**REQUEST**

Current Zoning: UC (urban core)  
Proposed Zoning: UMUD-O (uptown mixed-use district, optional)

Approximately 2.766 acres located on the west side of S Tryon Street, north side of Carson Boulevard, and east side of Winnifred Street.

The petition proposes development of the site under the provision of the UMUD zoning district with additional optional provisions.

RZ-2.00

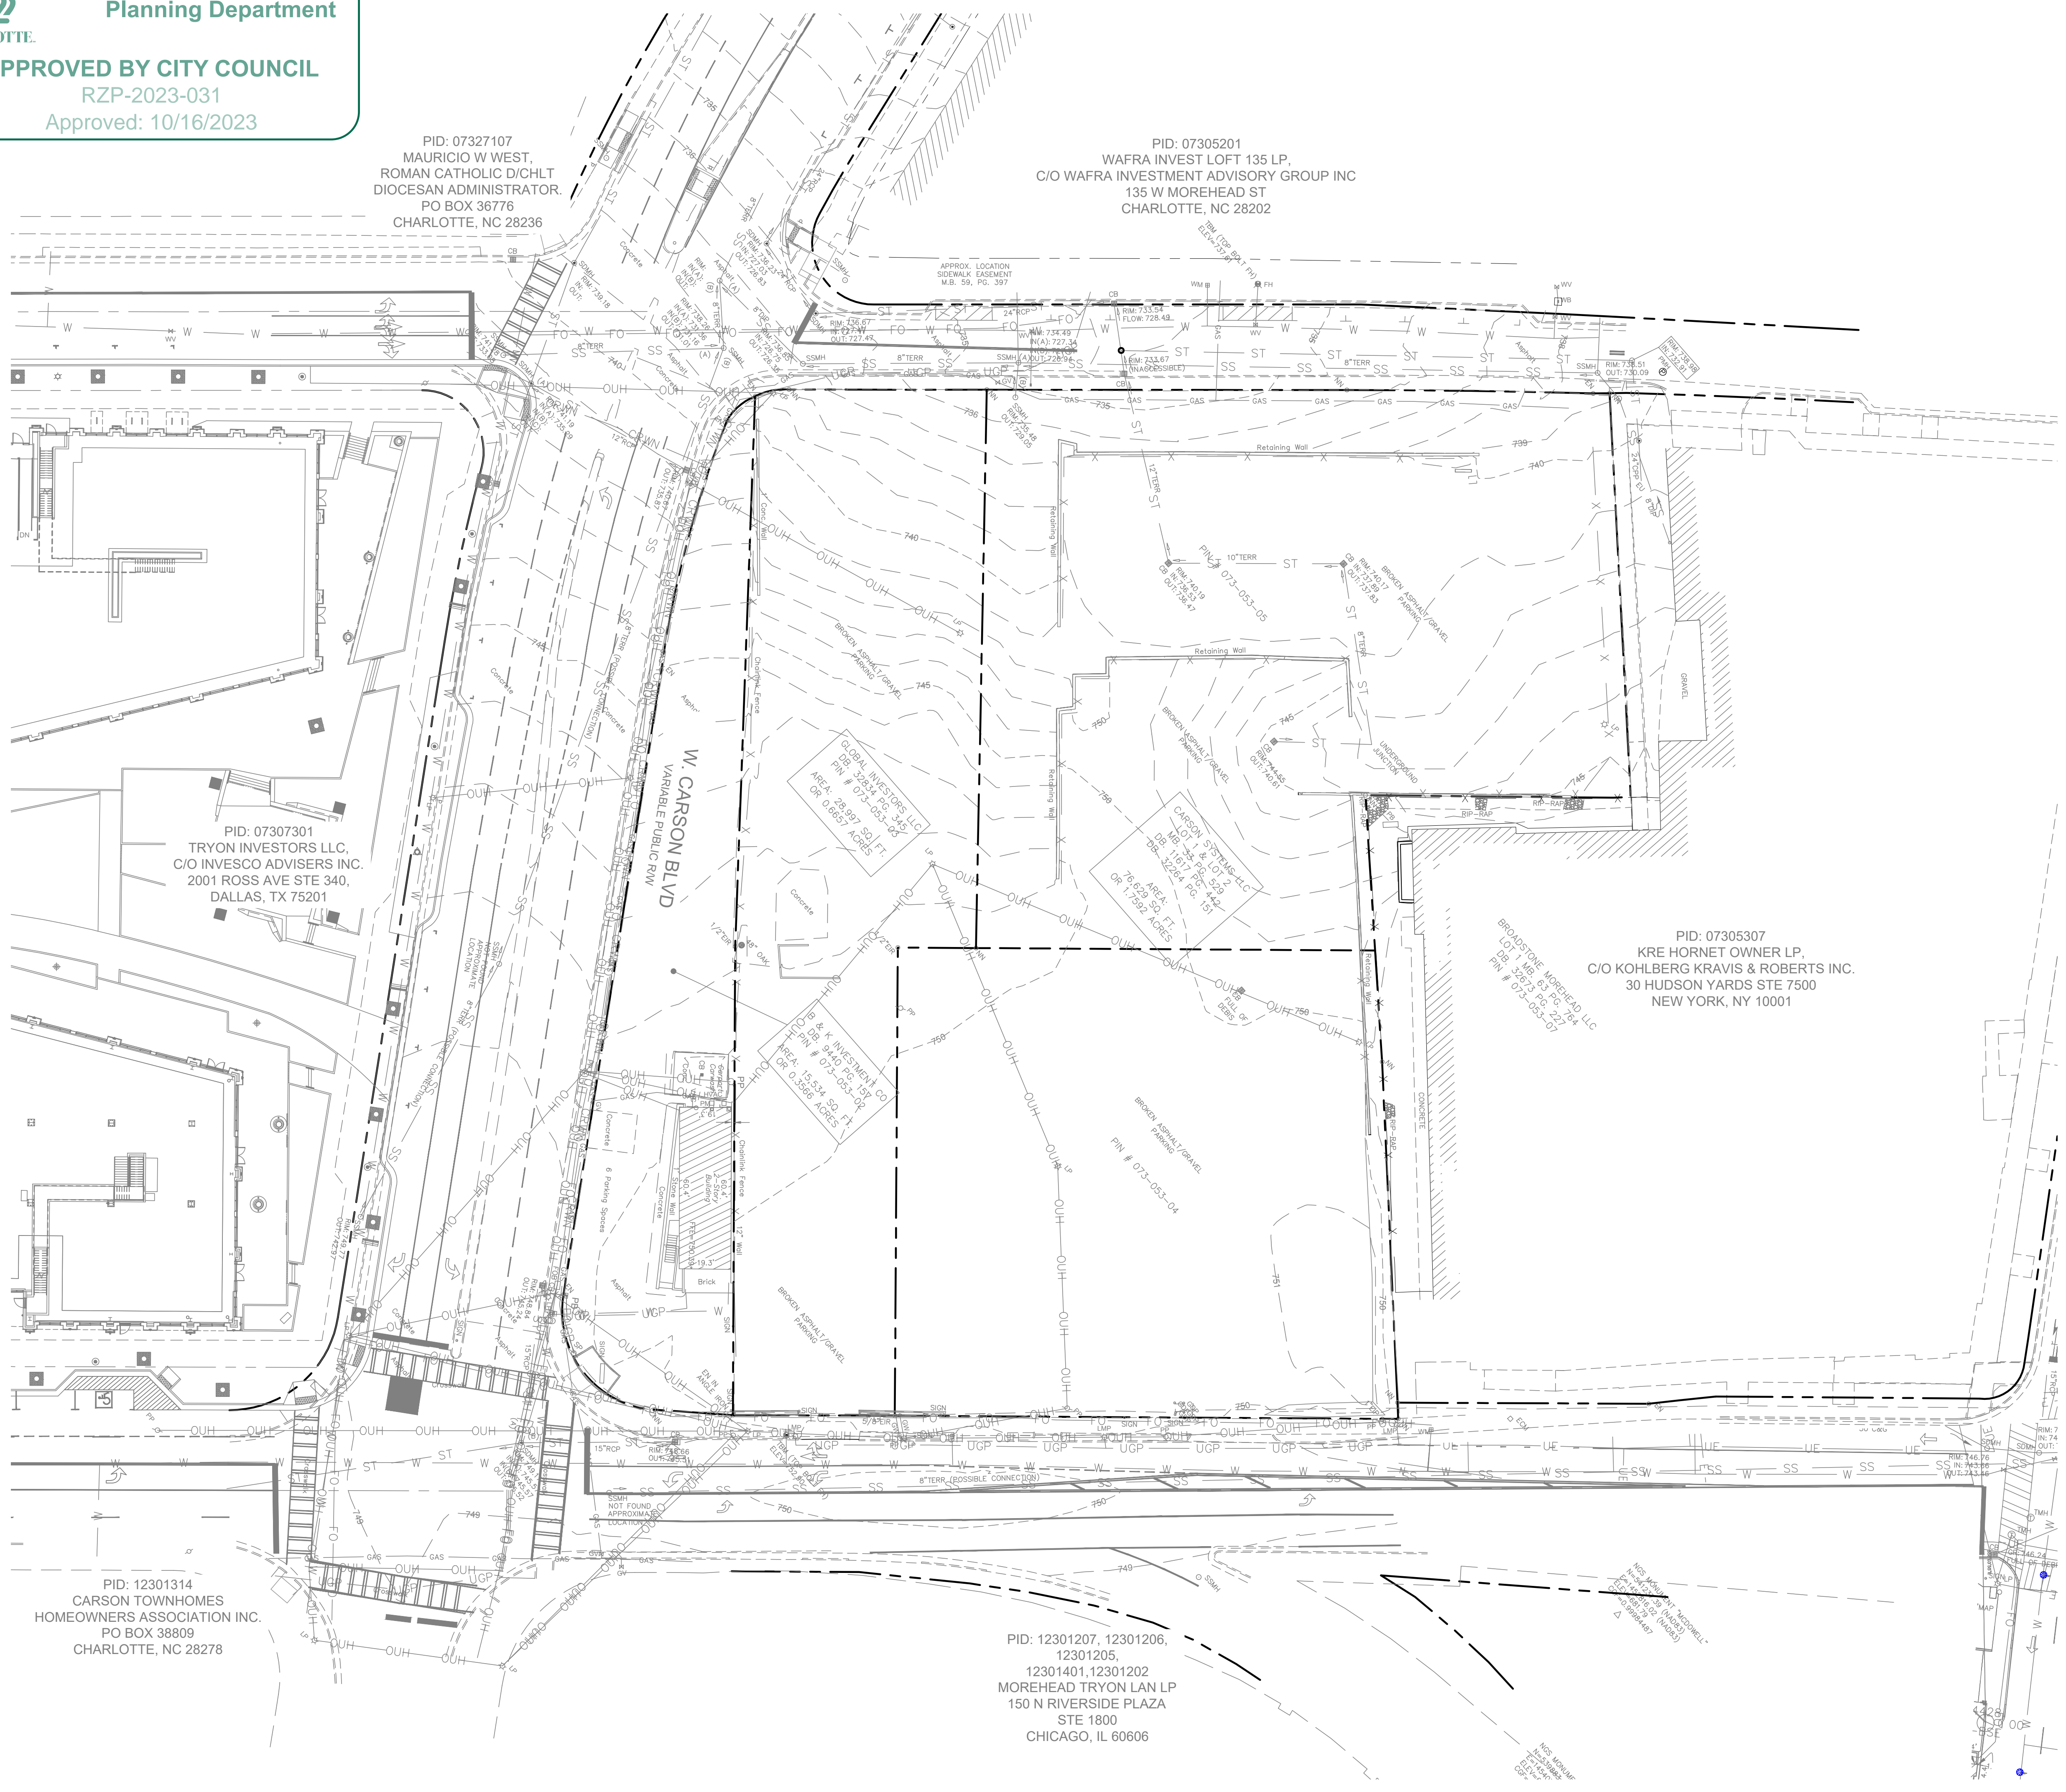
- ~~4. Revise Encroachment agreement note to the following: "A Right of Way Encroachment Agreement is required for the installation of any non standard item(s) (irrigation systems, decorative concrete pavement, brick pavers, etc.) within a proposed/existing City maintained street right of way by a private individual, group, business, or homeowner's/business association. An encroachment agreement must be approved by CDOT prior to construction/installation. Contact CDOT for additional information concerning cost, submittal, and liability insurance coverage requirements."~~ Addressed

~~5.—Remove optional provision for signage on curtain walls and windows.~~ Addressed

SHEET NUMBER
RZ-1.00

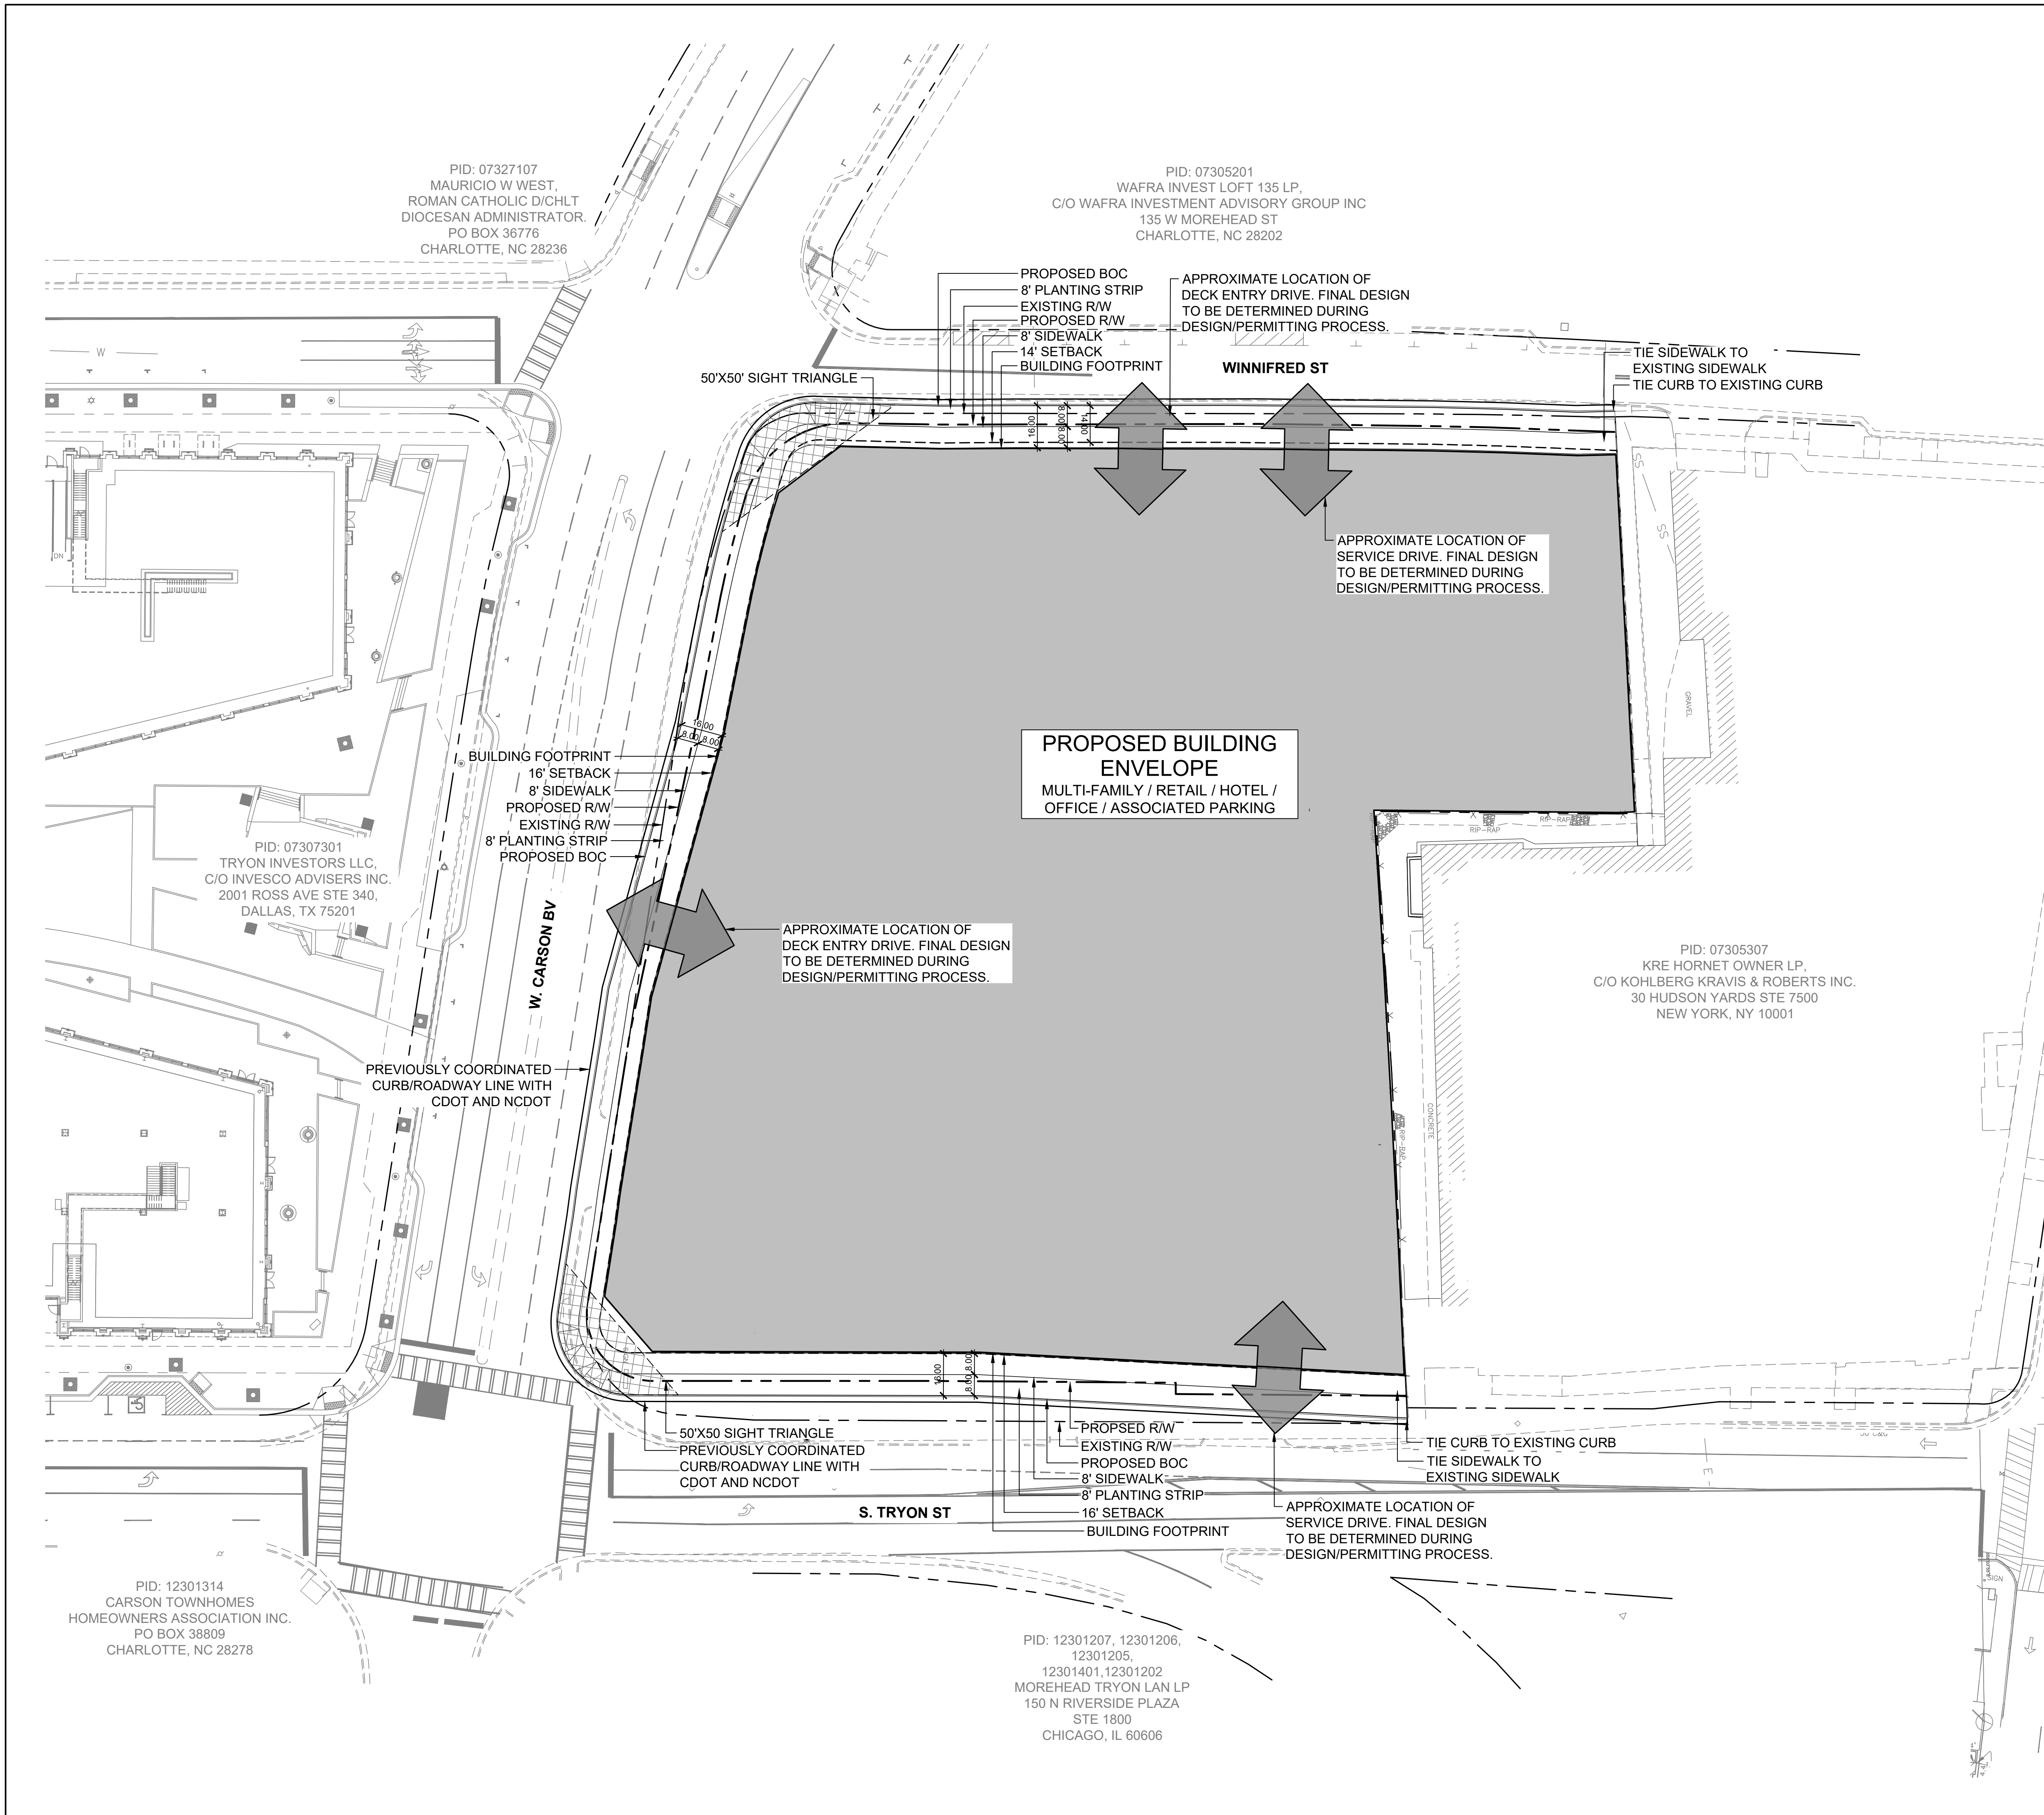
- ~~1. Curb lines need to be dimensioned on the site plan for each public road. Previously coordinated back of curb locations will be used.~~ Addressed
